RE: Charity Mom's Learning Center 833 Gibson Blvd. SE (L14D057)

Subject: Charity Mom's Learning Center 833 Gibson Blvd. SE (L14D057)

Prior to approve the TCL for the project mentioned above:

TRAFFIC CIRCULATION LAYOUT
SCALE: 1" = 20' - 0"

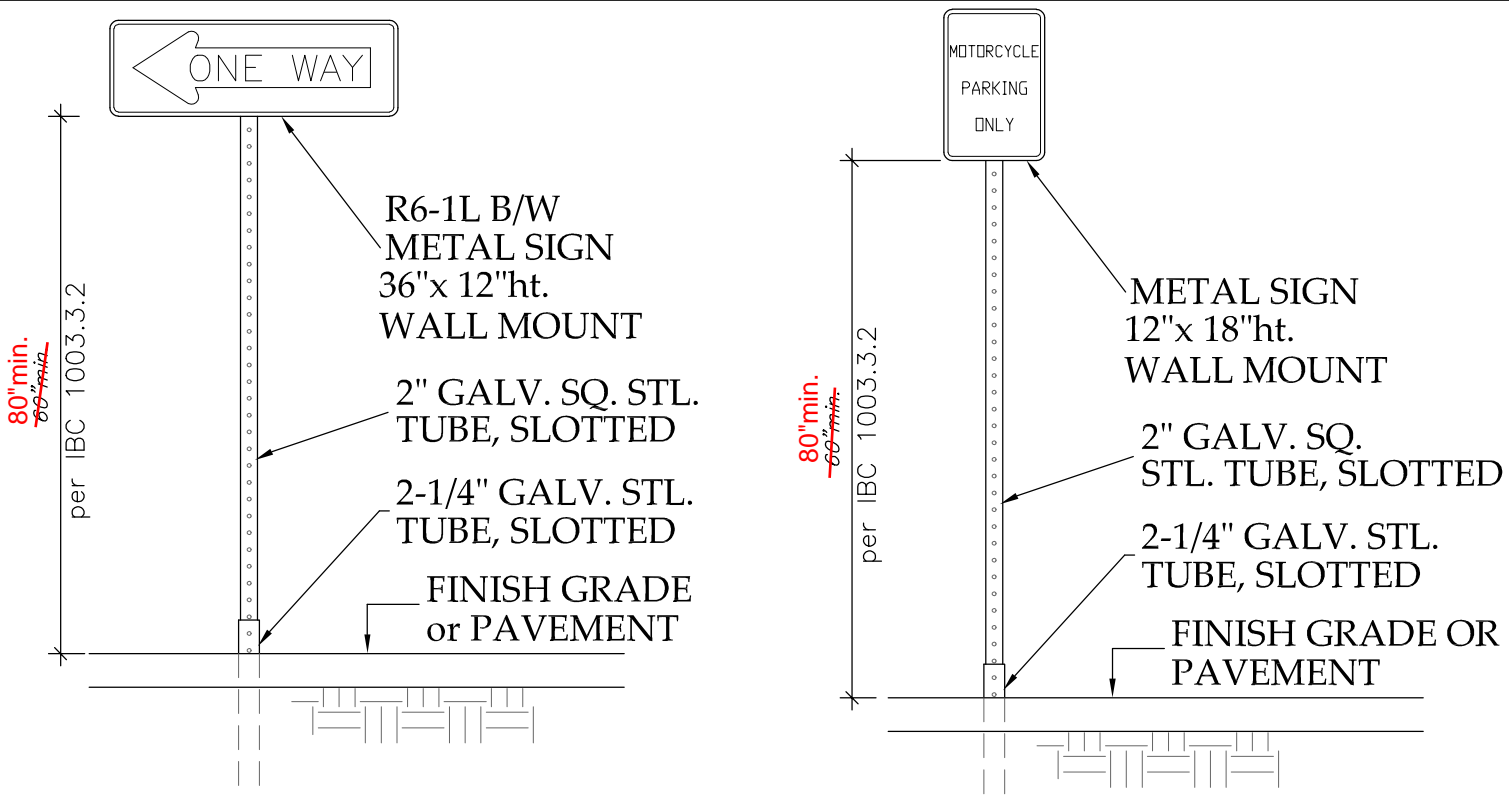
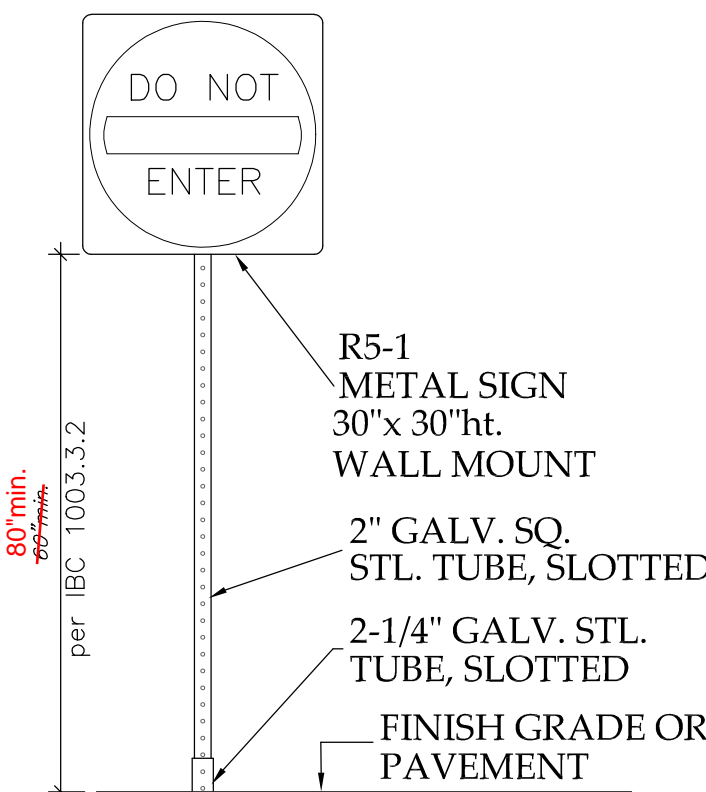
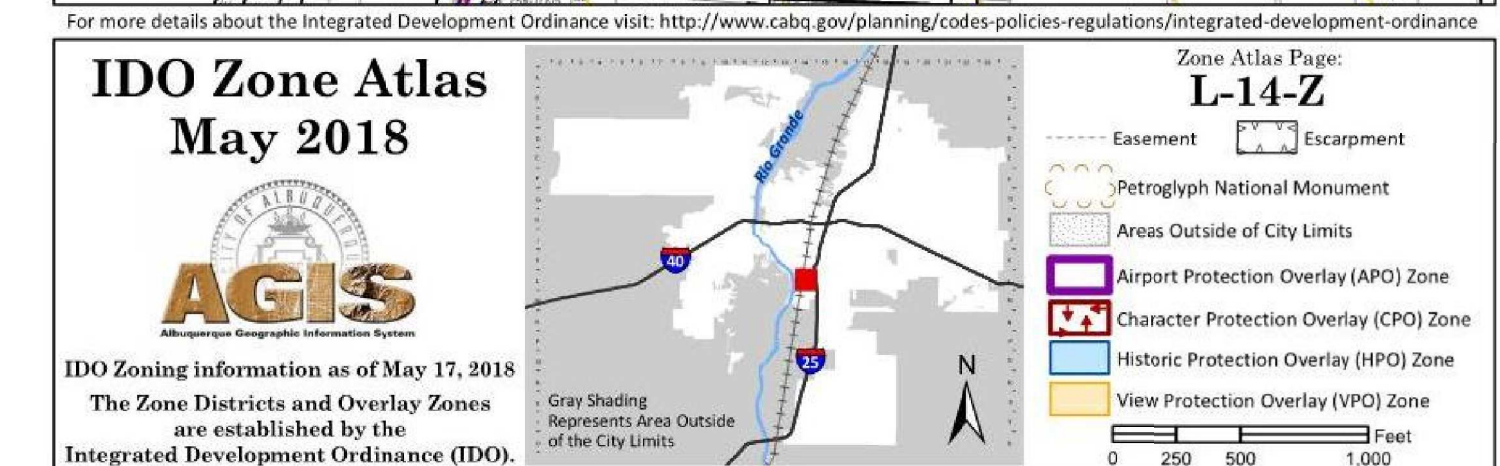
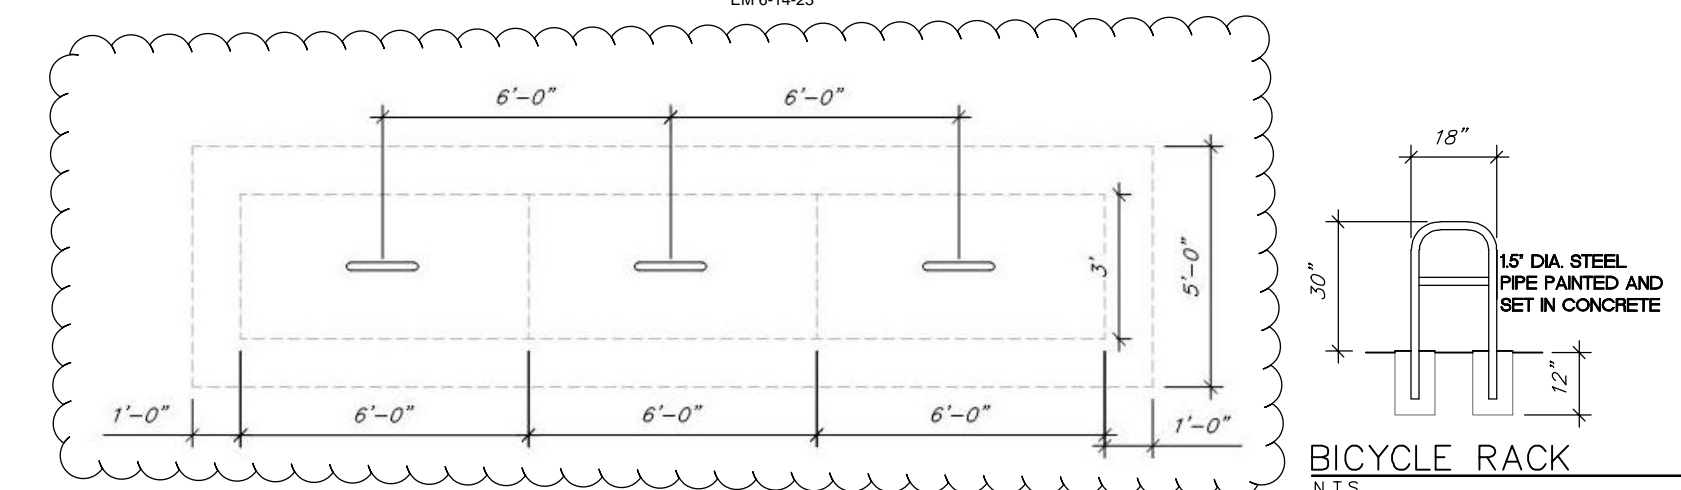
- Please provide the width for the existing drivepads accesses, existing drive aisles, and the one way drive. See attached blue marked site plan.
- Clear sight triangle must start at the back of the sidewalk. Please see attached.

- Define ADA pathways (from the public sidewalk and from ADA aisle to the building entrance) by labeling of ramps, flush pavement, dimensioning of pathways, doorways, etc.
